Application No: BE/42/21/HH
Site Address: 266 Chichester Road Bersted PO21 5AX
Description of works: Single storey rear extension with rear/side dormer, erection of detached garage & erection of front porch.

Thank you for your internet representation made on 19th May 2021 which has been recorded as an objection with the comments as follows:

PROPOSED EAST ELEVATION
SCALE 1:100

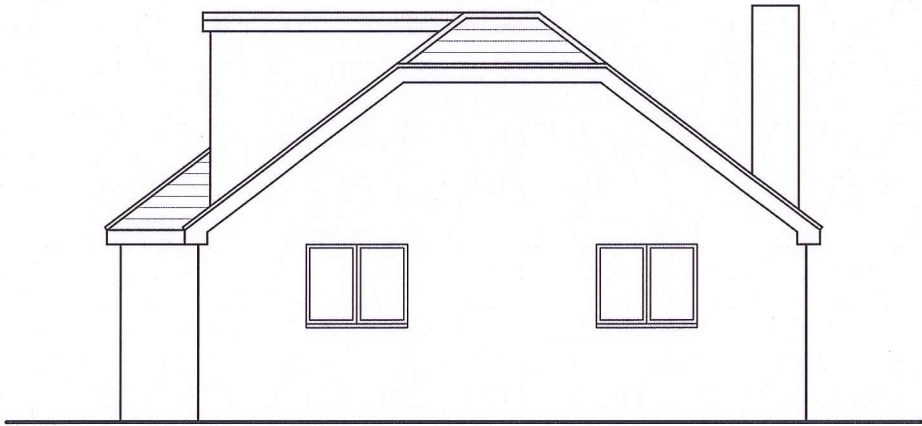
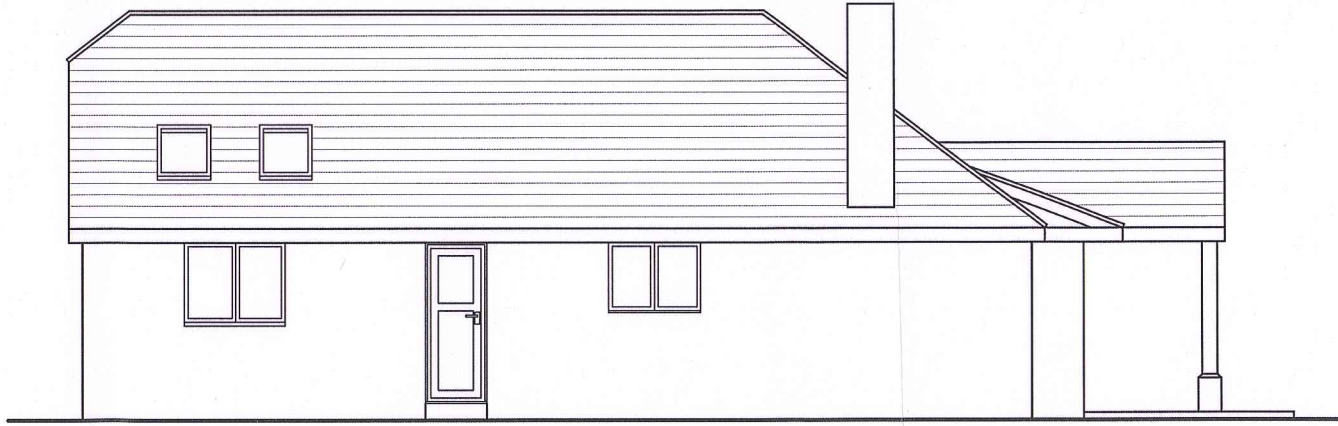
I strongly object to the proposed east elevation as this overlooks my garden and rear of my property imposing on our privacy.
